**RESPONSE TO COMMENTS:**

**2/23/21**

**Permit Application Number: 2001-170**

**9027 SE 60th. St.  
Mercer Island, Wa. 98040**

**A8**

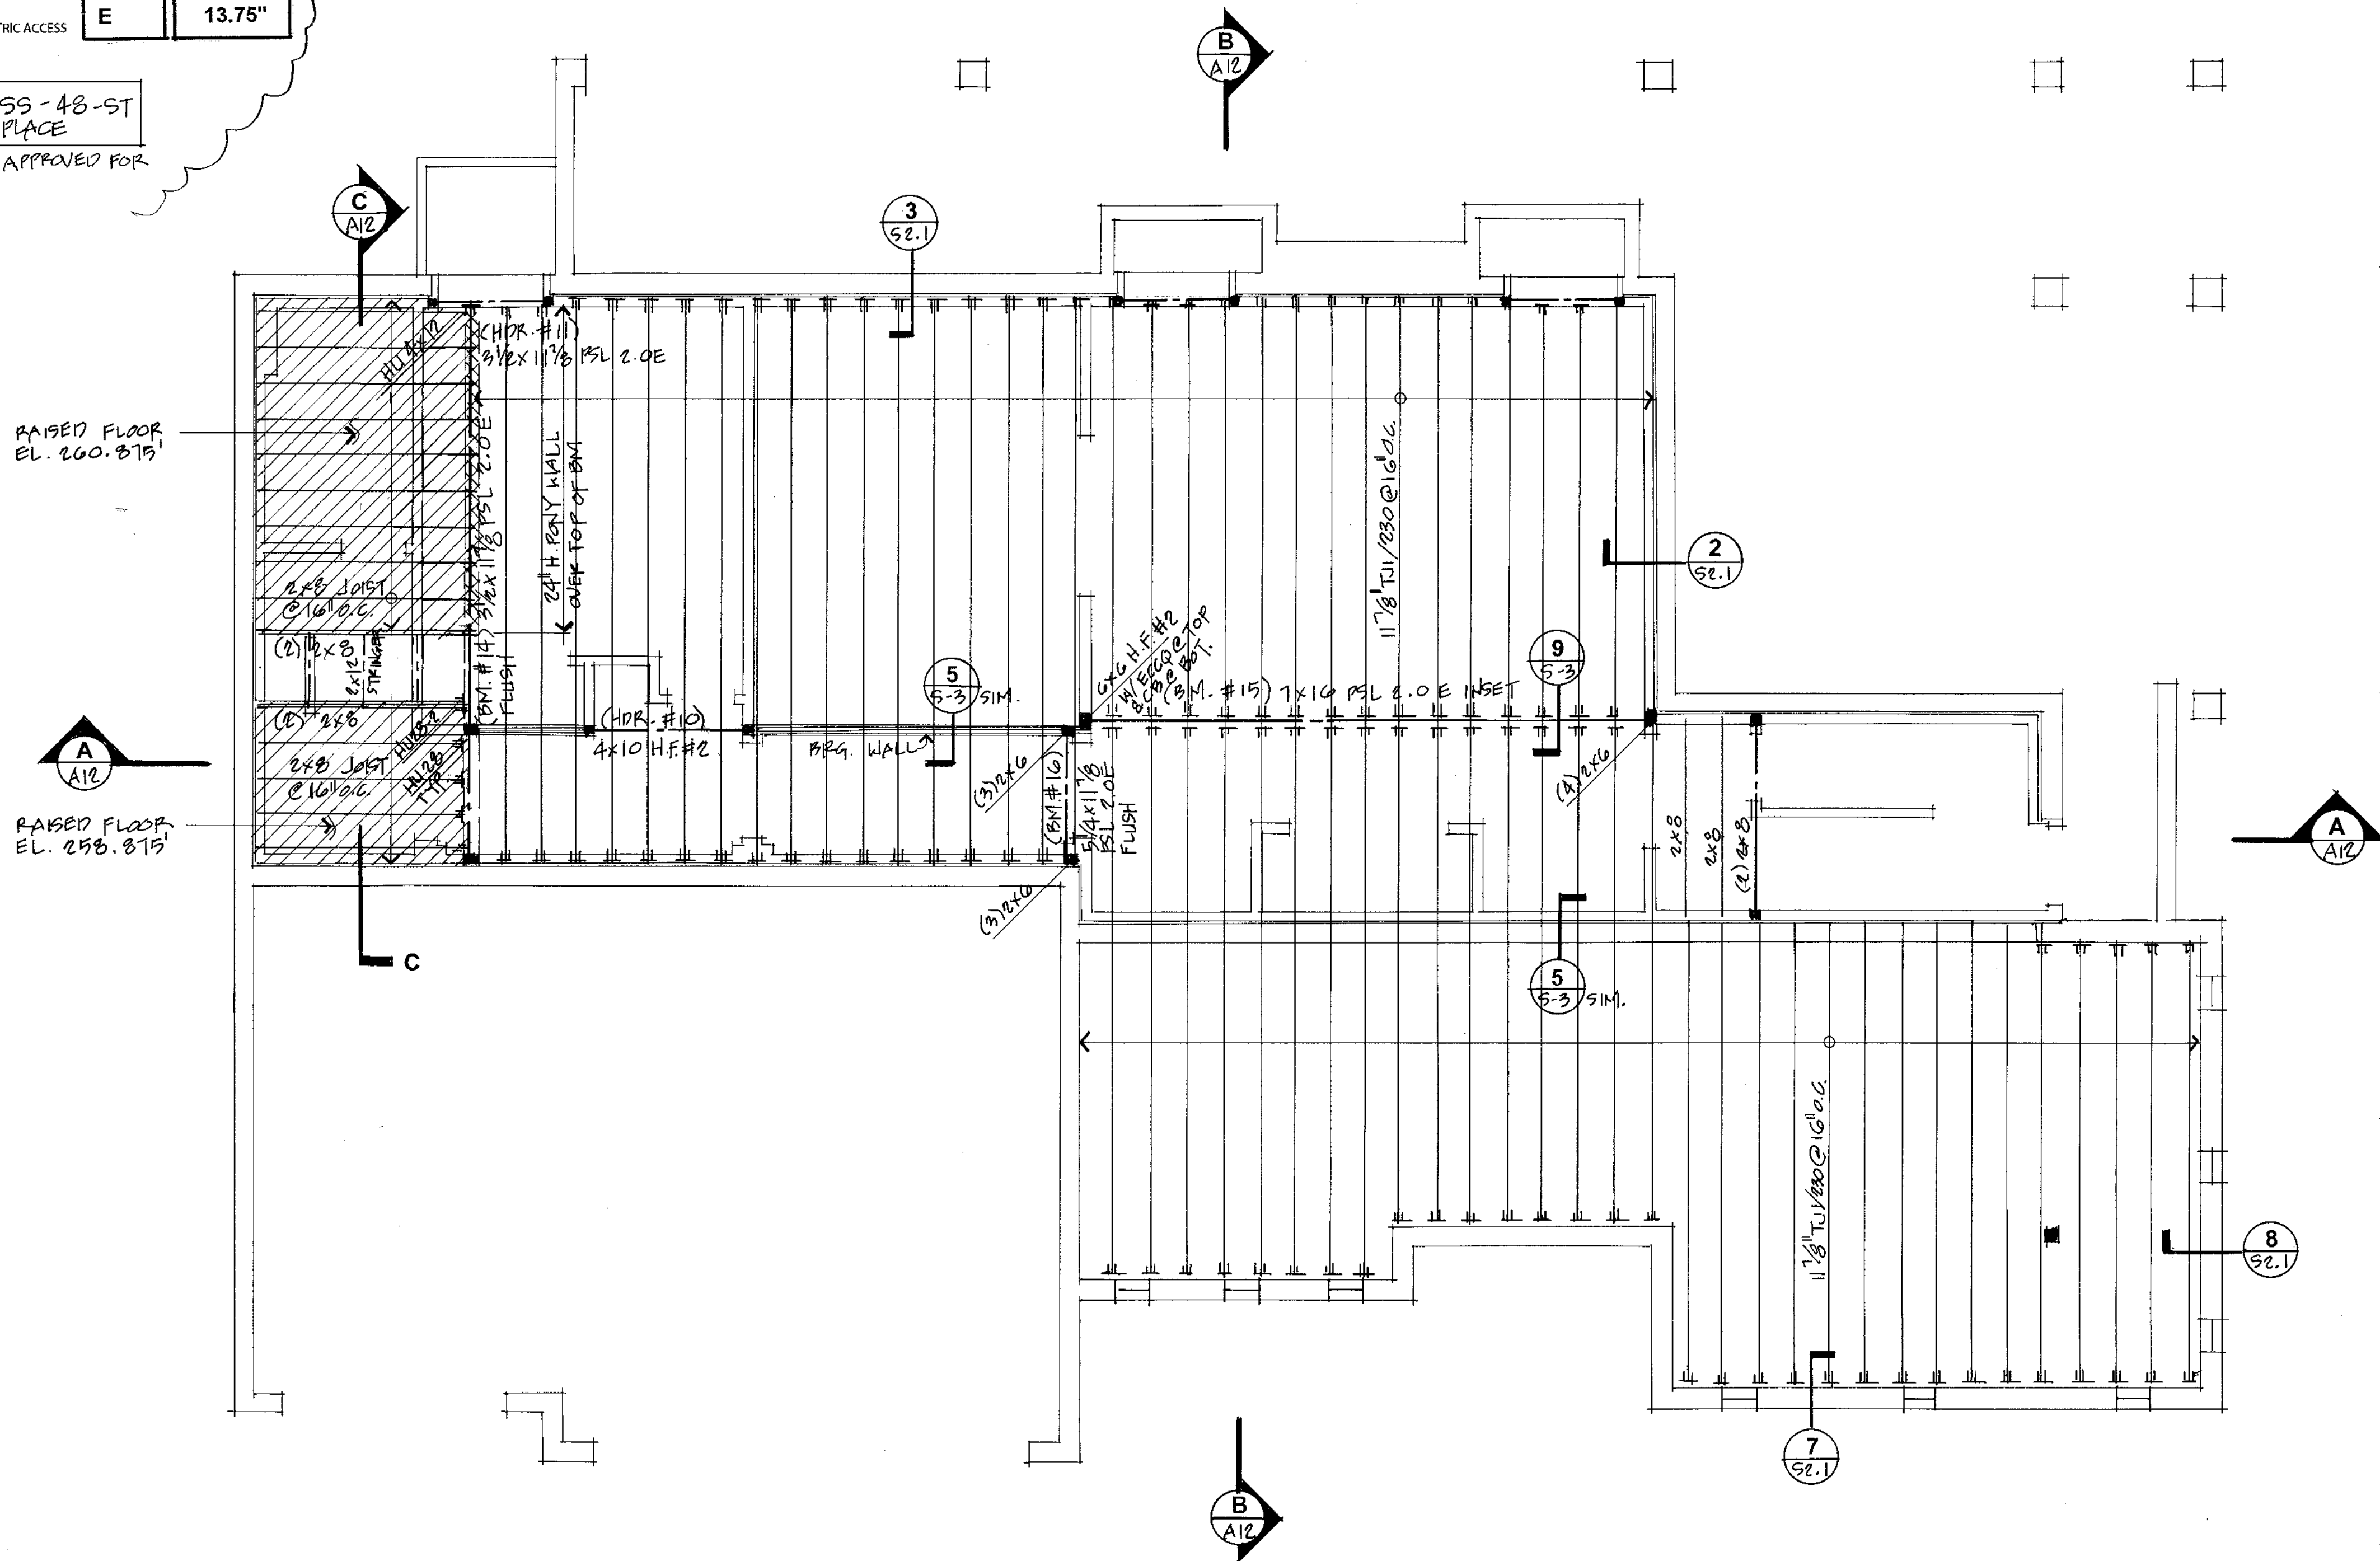
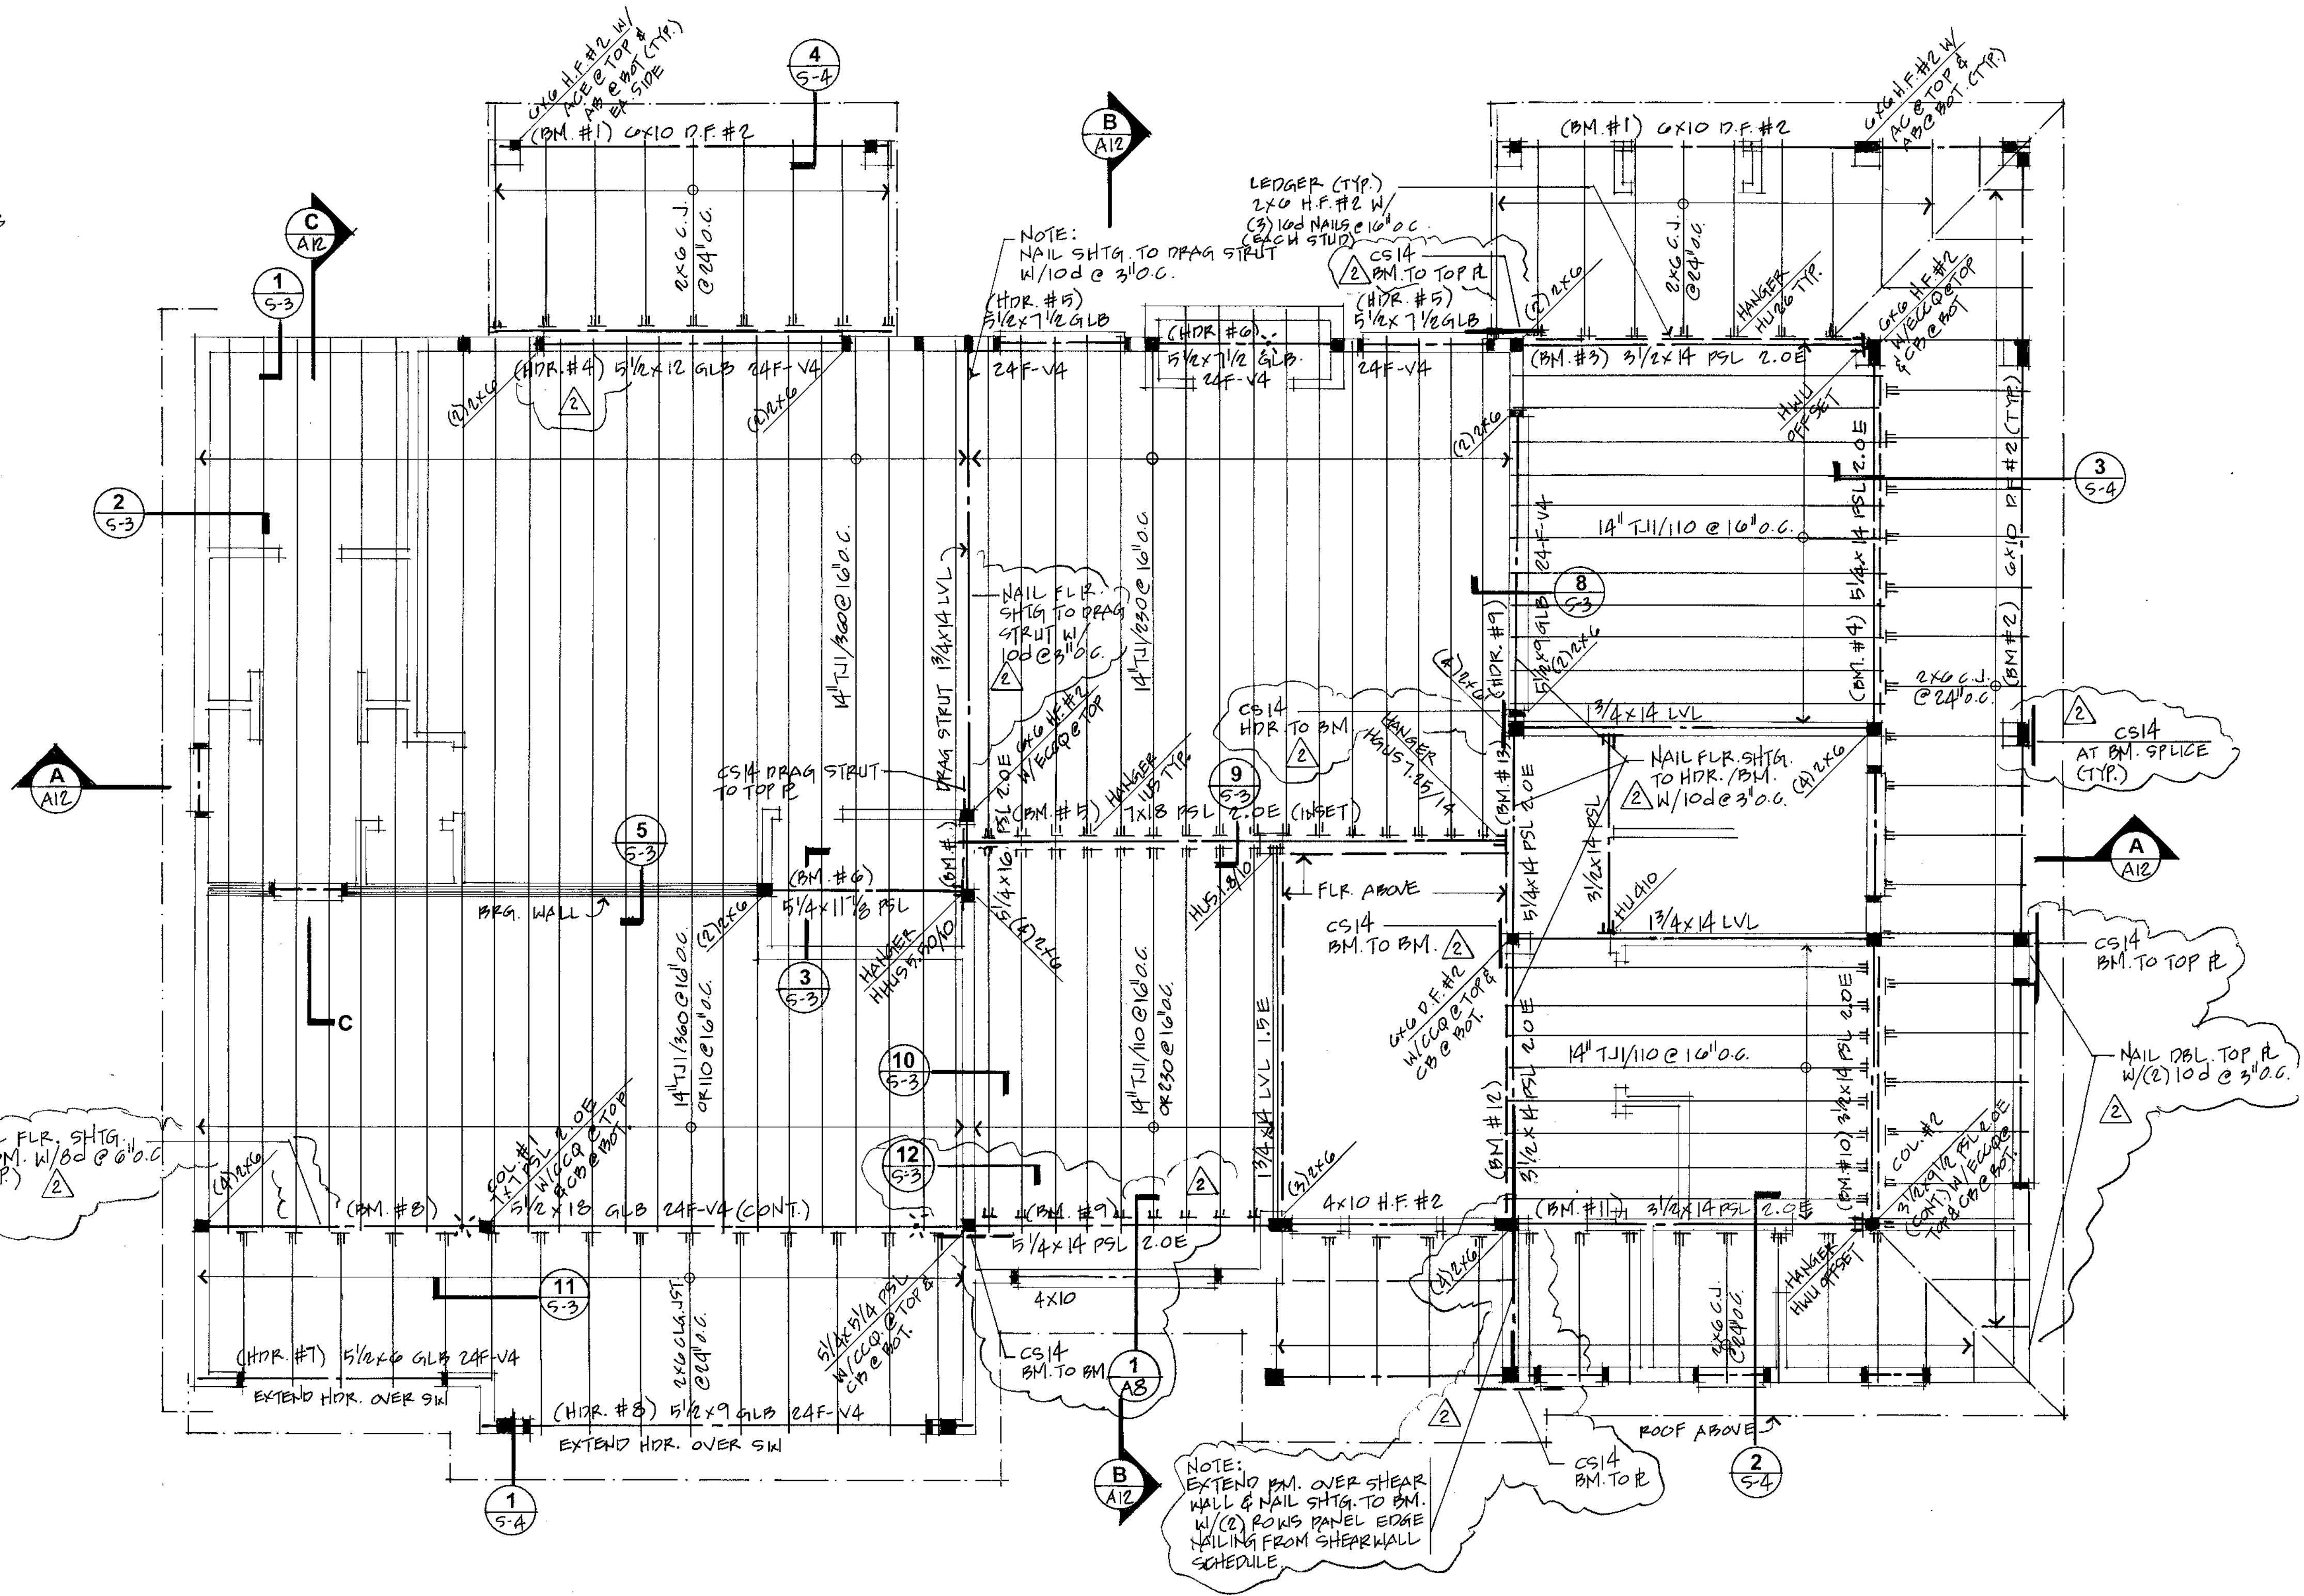
Page 13:  
Number 1: Added sheet A8  
Number 2: Added sheet A8, see structural  
Number 3: Added sheet A8, see structural  
Number 4: Increased stud columns to (4) 2x 6 sheet A8, see structural  
Number 5: Added detail 1/A8
